DRB Application No.: <u>04DRB-01799 (SBP)</u>	Project # <u>1003791</u>
Project Name: <u>Meridian Business Park</u>	
Agent: <u>Claudio Vigil Architects</u>	Phone No.: <u>842-1113</u>

**DRB Comments**

**RE: Lot 5, Meridian Business Park/SPBP**

**LANDSCAPE PLAN**

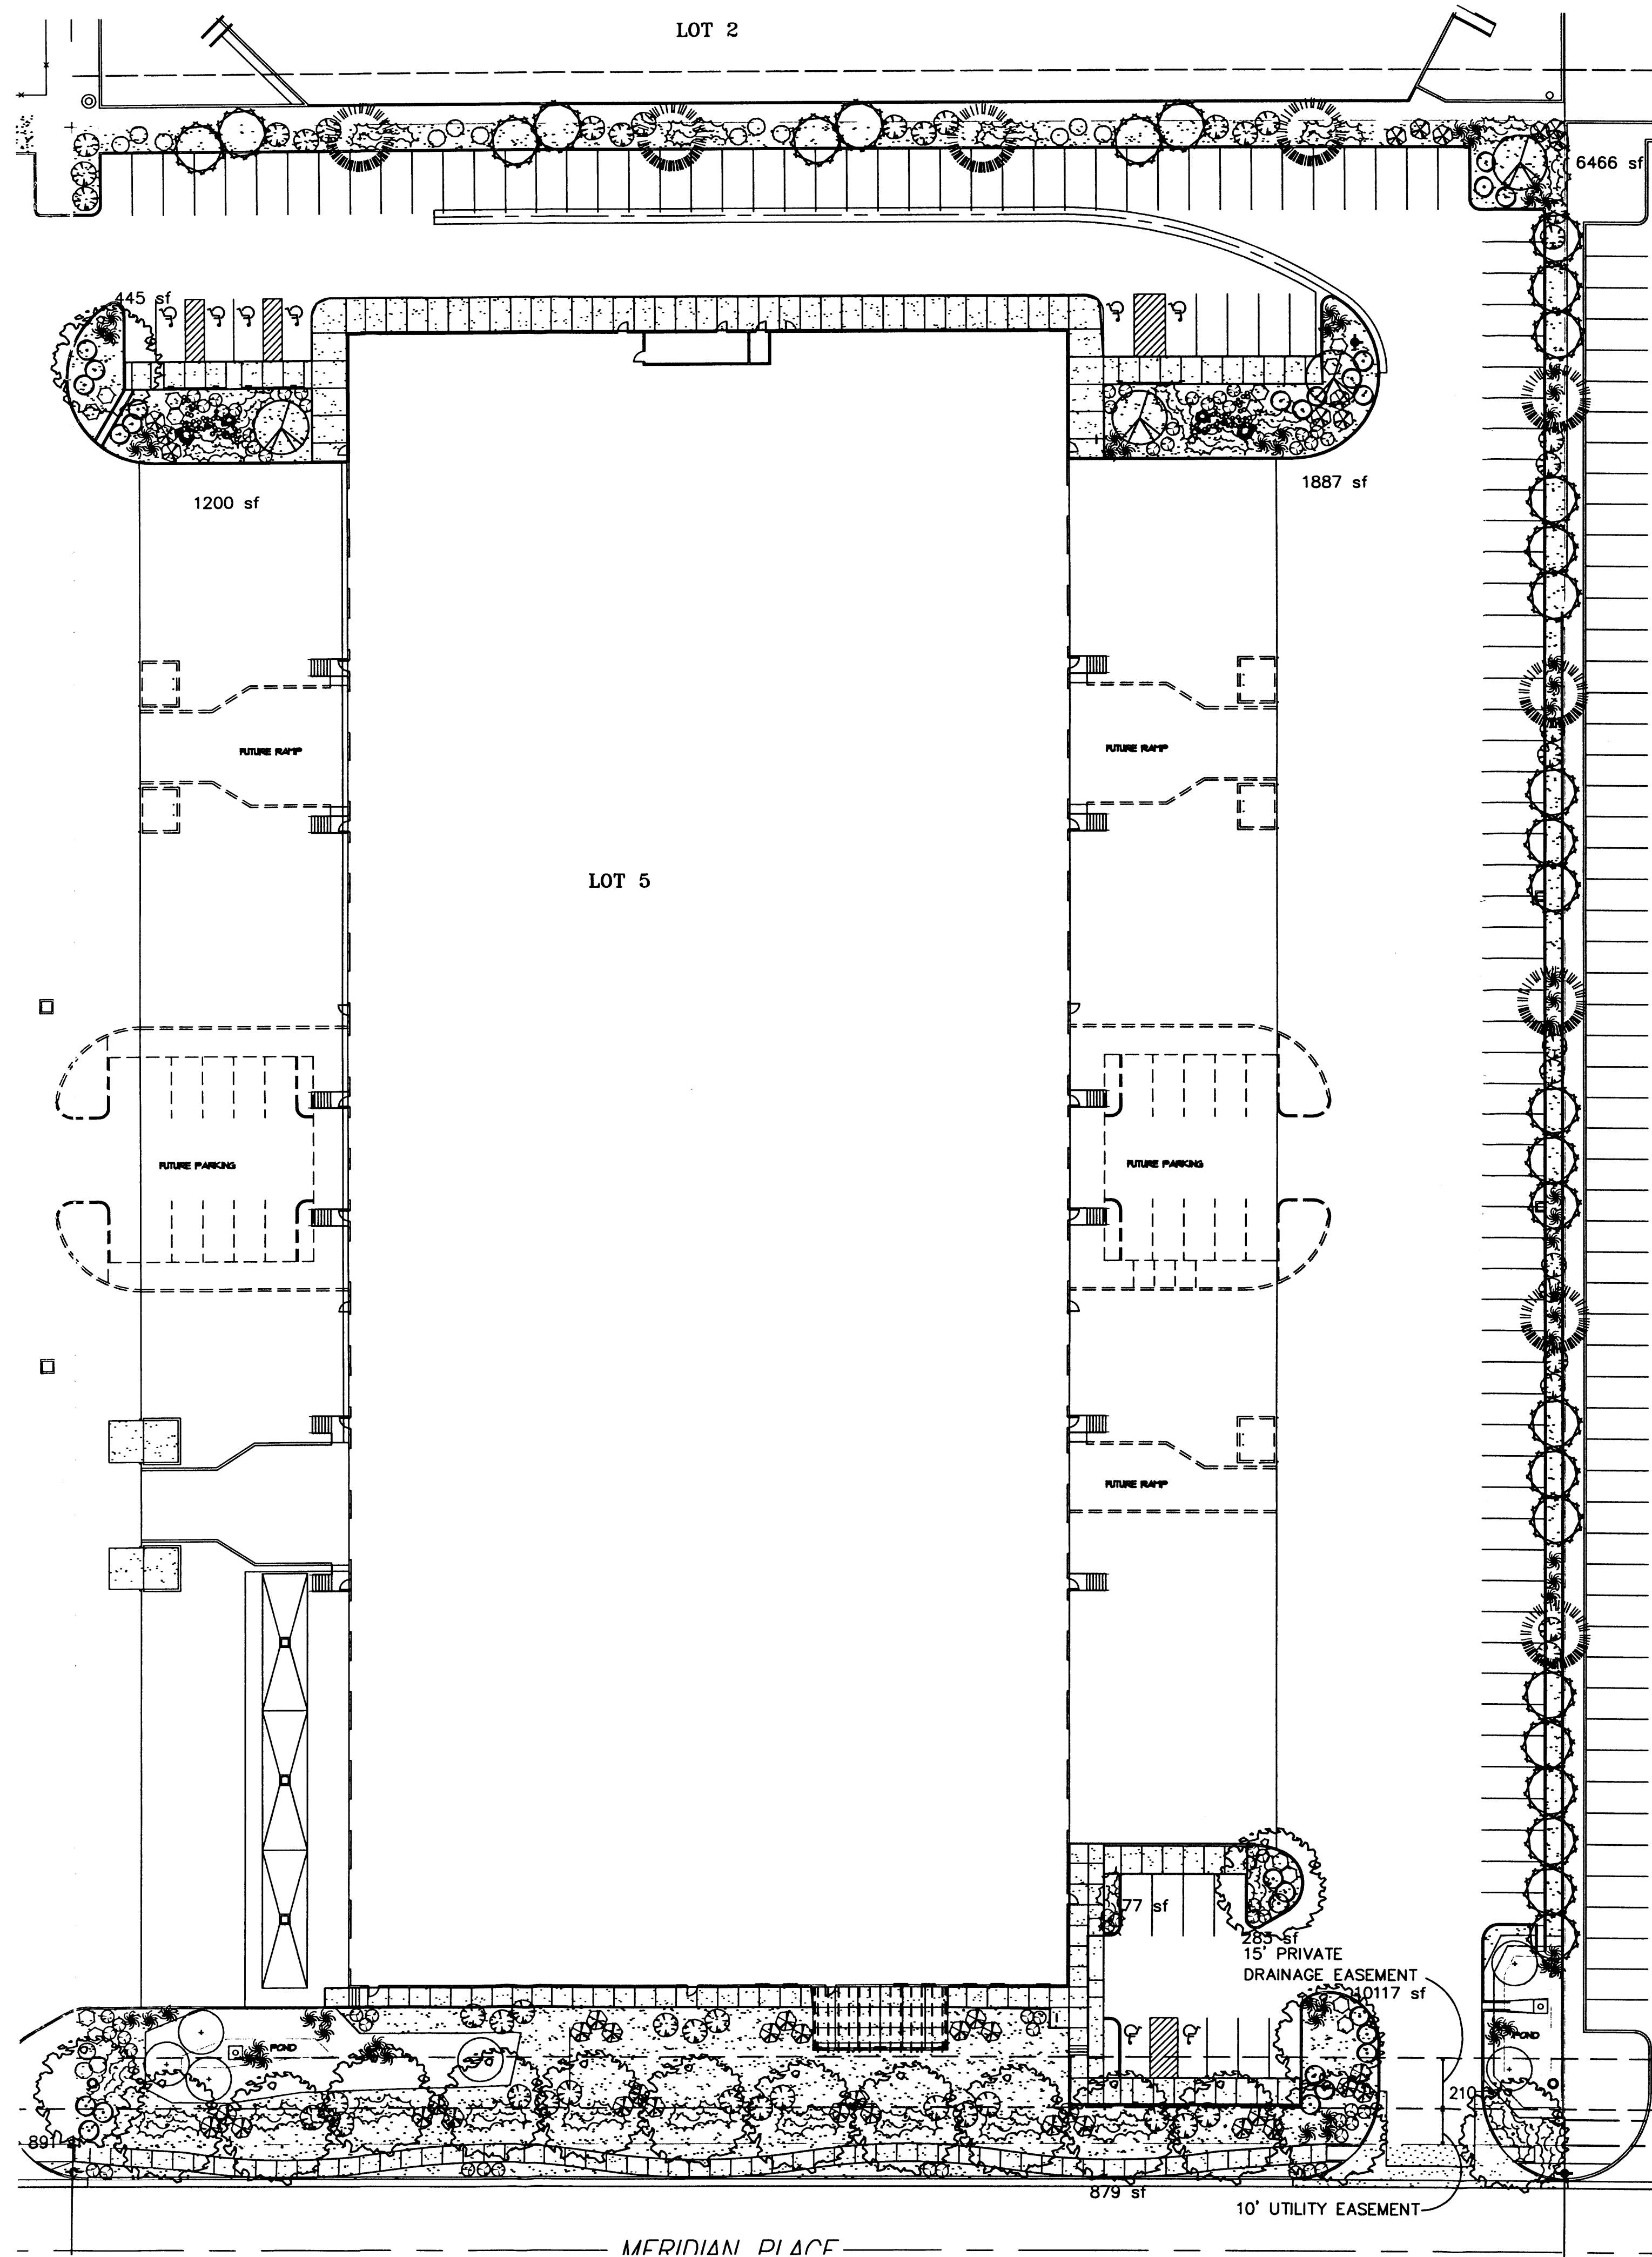
- ✓ The Master Plan requires a 70/30 percent mix of deciduous/evergreen trees per the Admin. Amend. approved in 1997. The trees listed are all deciduous.
- ✓ The Landscape Plan should have the existing & proposed easements shown per the Checklist.
- ✓ The building mounted signs should have the colors listed.
